**KIRKLEES METROPOLITAN COUNCIL
INVESTMENT & REGENERATION SERVICE**

**DELEGATED DECISION TO DETERMINE APPLICATIONS FOR
CONSENT, AGREEMENT OR APPROVAL REQUIRED BY CONDITION**

Reference No:	2024/44/93394/W
Site Address:	land between, Bradshaw Road and Honey Head Lane, Honley, Holmfirth, HD9 6EE
Description:	Discharge of details reserved by conditions 3 (access and parking provision), 4 (parking and visitor parking), 5 (turning facilities), 6 (construction traffic), 7 (collection of wastes), 11 (external materials), 12 (boundary treatments) on previous 2024/90616 permission for erection of two detached dwellings
Recommending Officer:	John Holmes

DECISION – Discharge of Condition - Approved

| PAPER SIZE<br><b>A2</b>                              | DWG NUMBER<br><b>(70)002</b> | DATE<br><b>15/11/23</b> | REVISION<br><b>/</b>                   |

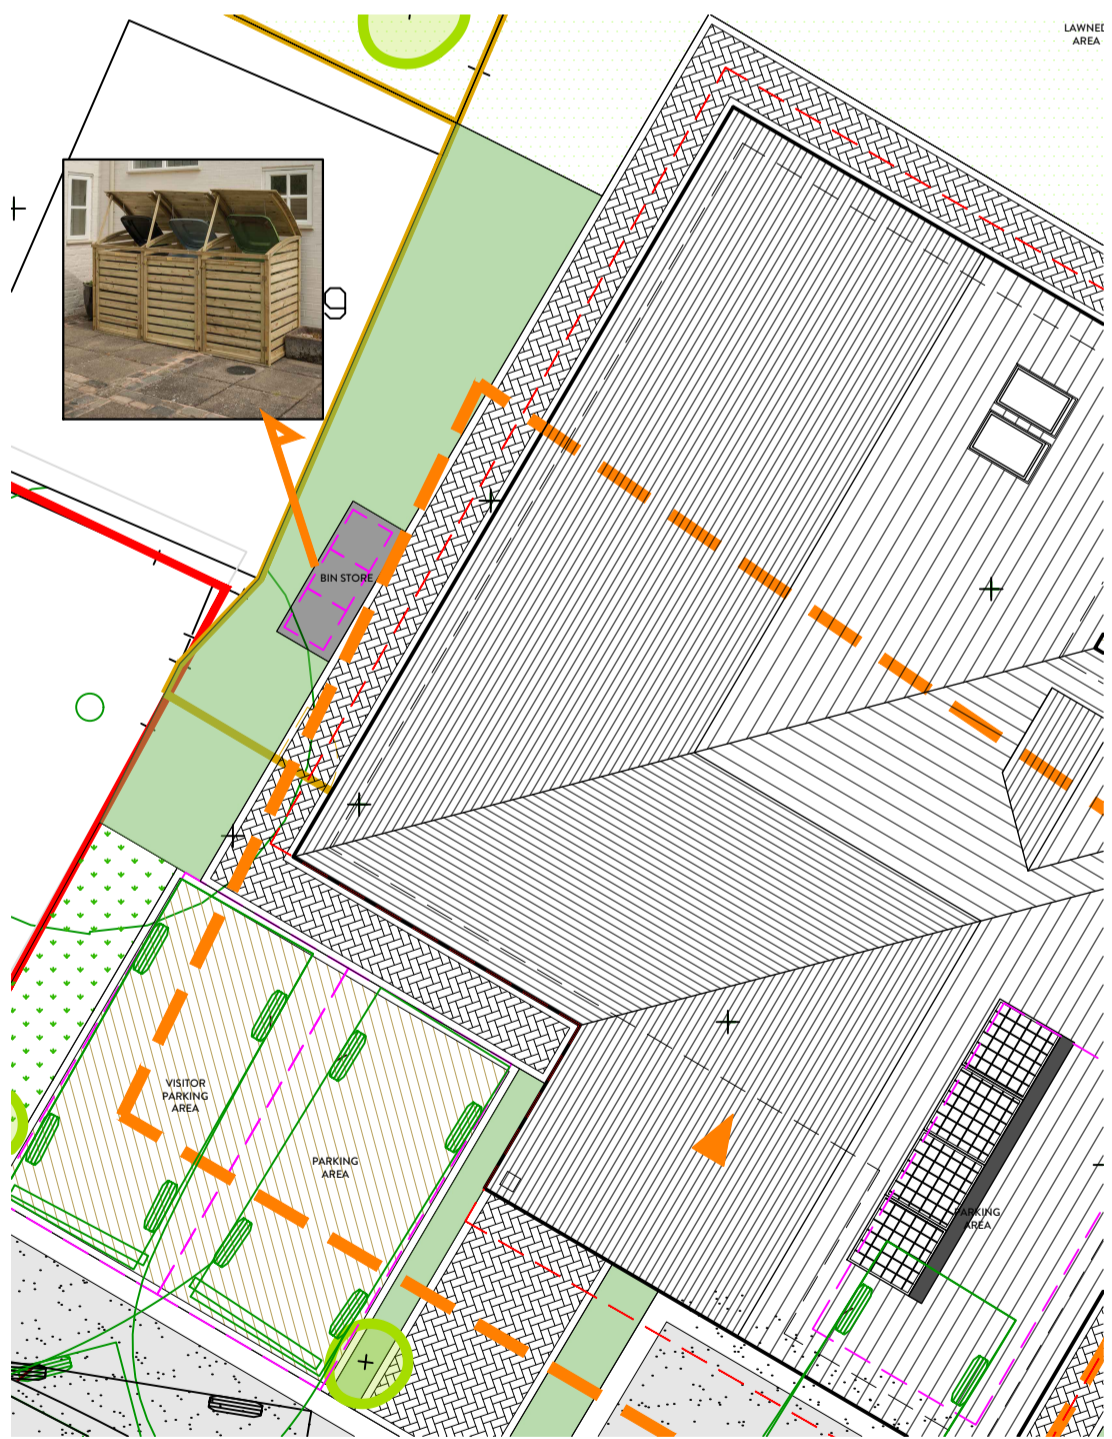
The information provided for the waste storage and collection points as shown on drawing No (70)002 are acceptable for the discharge of condition 7. However it should be noted that the bin storage and presentation points for plot 1 are separated by the car parking area and this may cause problems for the occupier on collection day if cars are parked in both spaces and the bins are required to be moved.

The submitted scheme satisfies the information requirements of the condition. The comment of the Highways Team is noted in relation to plot 1, however it is considered this is balanced against the visual impact of bin storage in a location adjacent to the front elevation.

It is considered the submitted scheme sets out a suitable scheme in relation to waste storage and it is concluded this scheme would acceptably impact upon amenity and highway safety and meet the requirements set out in Local Plan Policy LP24 part d(vi), Chapter 9 of the National Planning Policy Framework and Principle 19 of the Housebuilders Design Guide SPD. The scheme is therefore considered acceptable to discharge condition 7.
